2024/90235 (condition 10)

2024/90236 (condition 11, 12 & 14)

2024/90237 (condition 03, 04, 05, 06, 07, 09 & 18)

03 BOUNDARY TREATMENT - ADJACENT BUILDING SECTION SCALE 1:20

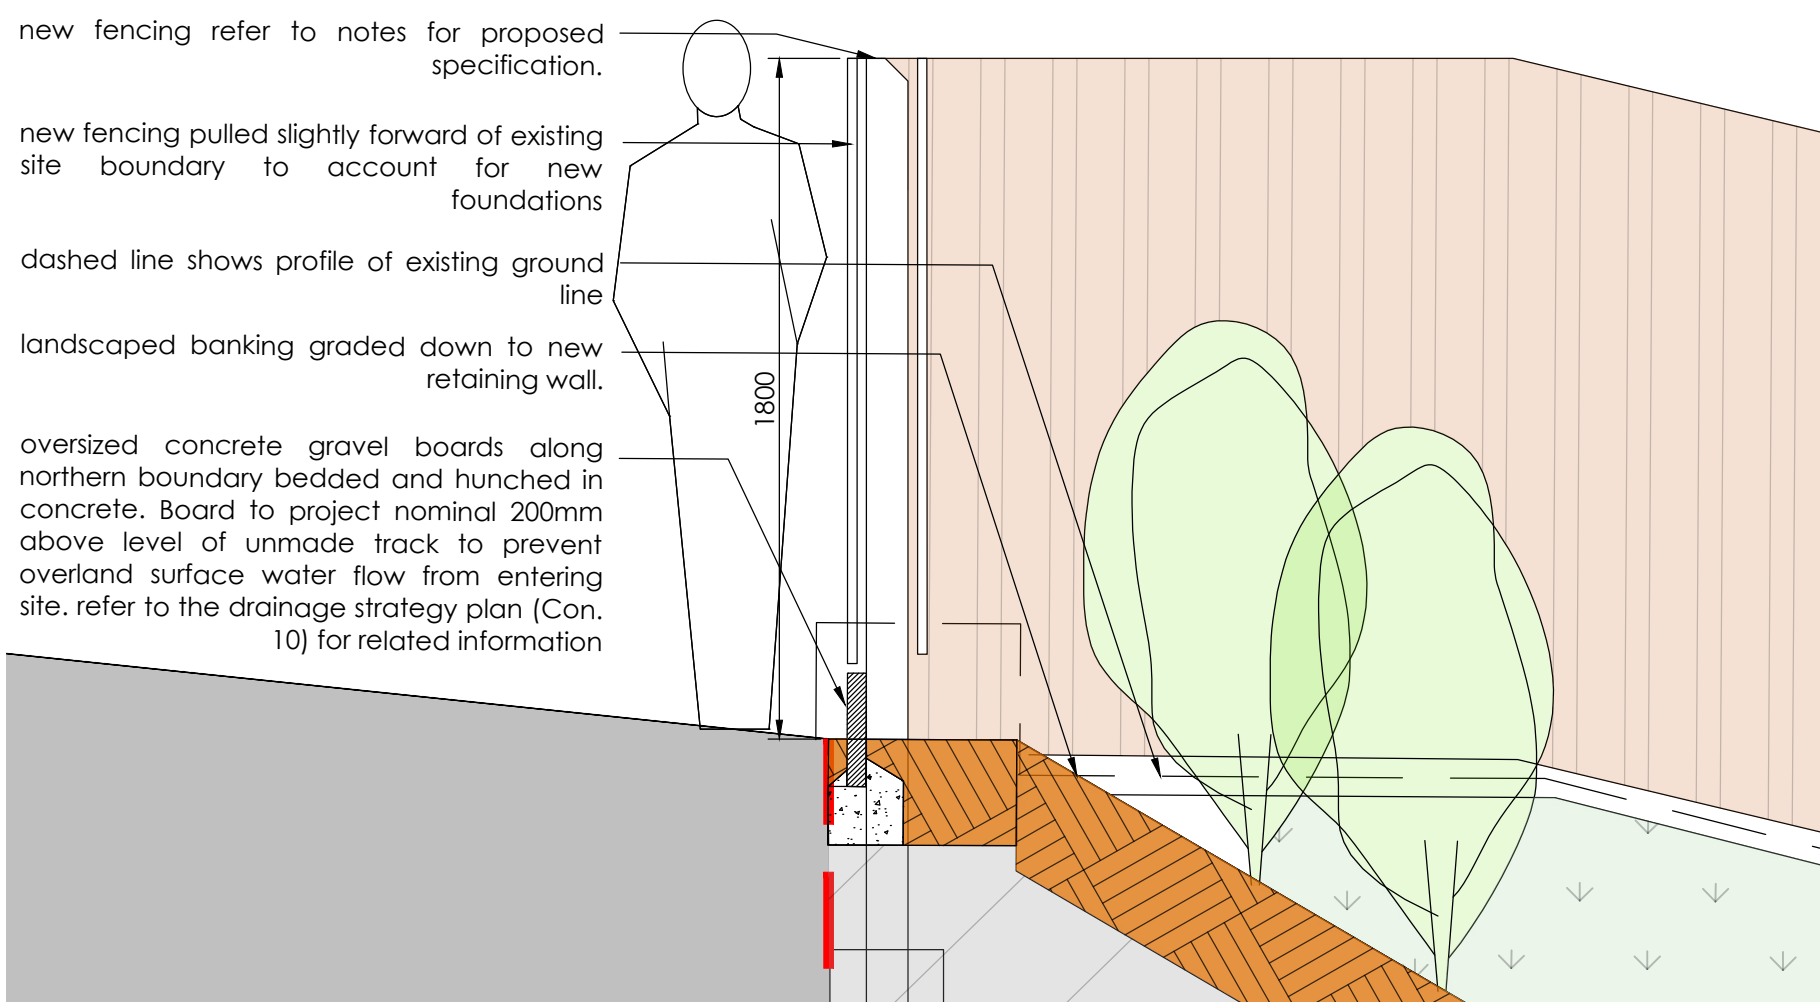
- *We also recommend the planning officer look at boundary treatments to the north which suggest a wall on some plans but a fence on others. A solid wall at the base is needed to deflect external flood routing down the track rather than onto site.*

- condition 10 (timescale: prior to above ground works commencing)
- please refer to the Appendix G – Condition 10: Drainage Addendum which has been prepared by GeoSmart to answer the above query.
- Please refer to detail 04 on drawing – 23-035/102 which shows an oversized continuous concrete gravel board is proposed at the base of the fence to direct water accordingly. the concrete gravel board presents a less permeable option than a masonry wall which has numerous mortar joints. For ease we have attached the detail 04 (Appendix H – Condition 10: boundary detail)
